Approval of details reserved by condition under BN/38/24/PL relating to conditions 5- gain plan, 7 - fire hydrant , 16 - cycle parking, 19 - further surveys, 20 - green roof, 21 - bat friendly lighting, 22 - bat boxes , 23 - bird boxes & 24 - bee bricks. (See Application BN/12/26/DOC for conditions 8 & 9 - drainage).

Land East Of The Croft Surgery Barnham Road Eastergate PO20 3RP

Arun District Council have decided to **APPROVE details reserved by this condition**

DRAWING NO: AWC0031-W001
DATE: 05/01/2026
APPROVED BY:
DRAWN: MA
CHECKED BY:
ISSUED: 00
SCALE: AT A2: 1:500
APPROVERS SIGNATURE:

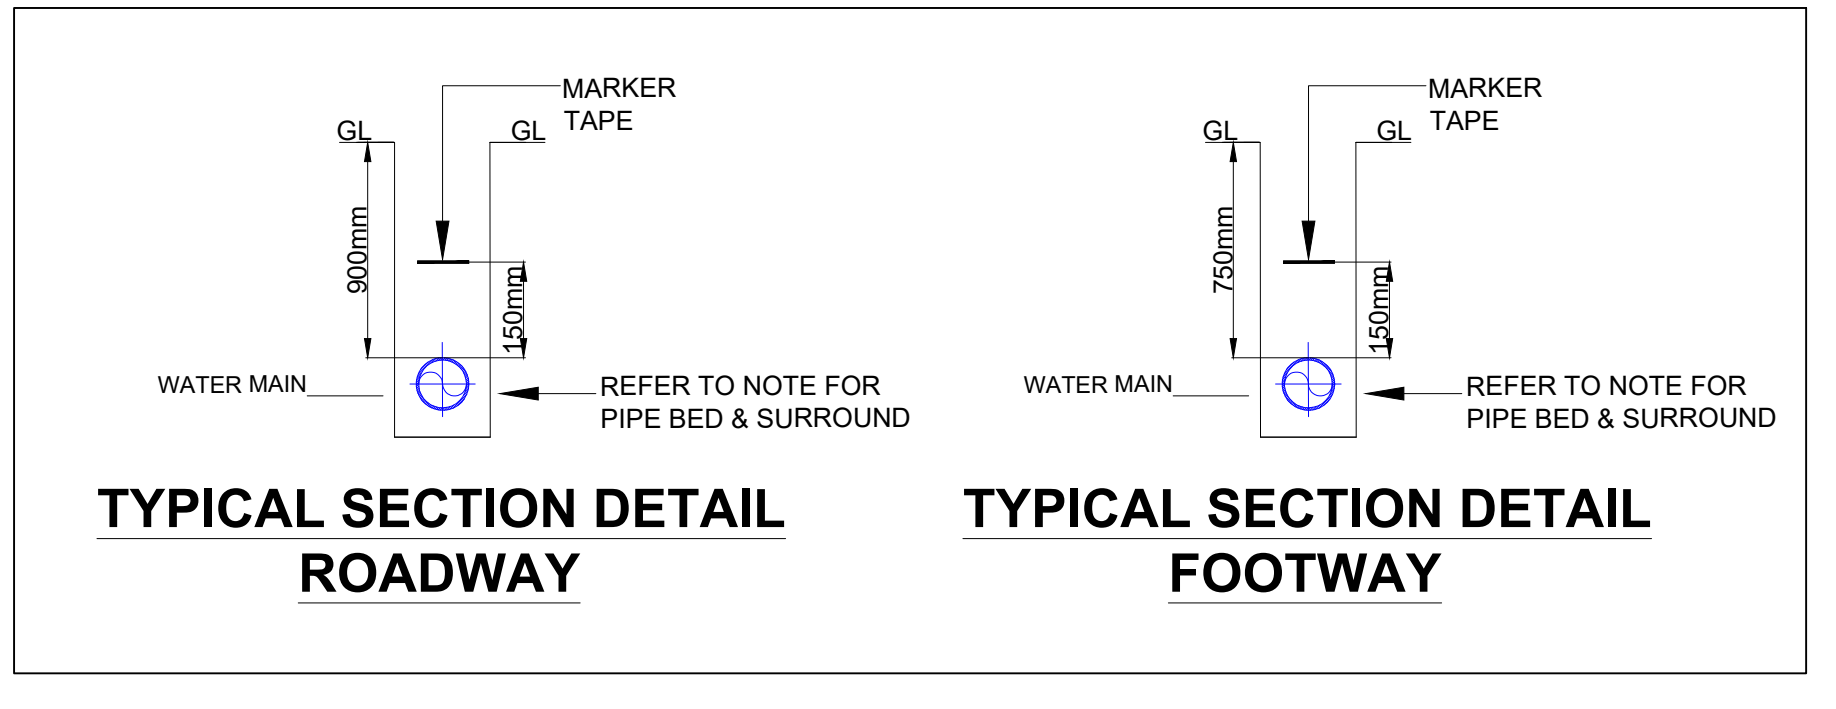
This condition has been subject to consultation with WSCC Fire and Rescue. They have provided no objection, following review of the submitted plans and commitment from the developer that WSFRS will be informed of their implementation as soon as they are in place and ready for use / adoption. The following details are therefore acceptable:

- Water Construction Plan - AWC0031-W001
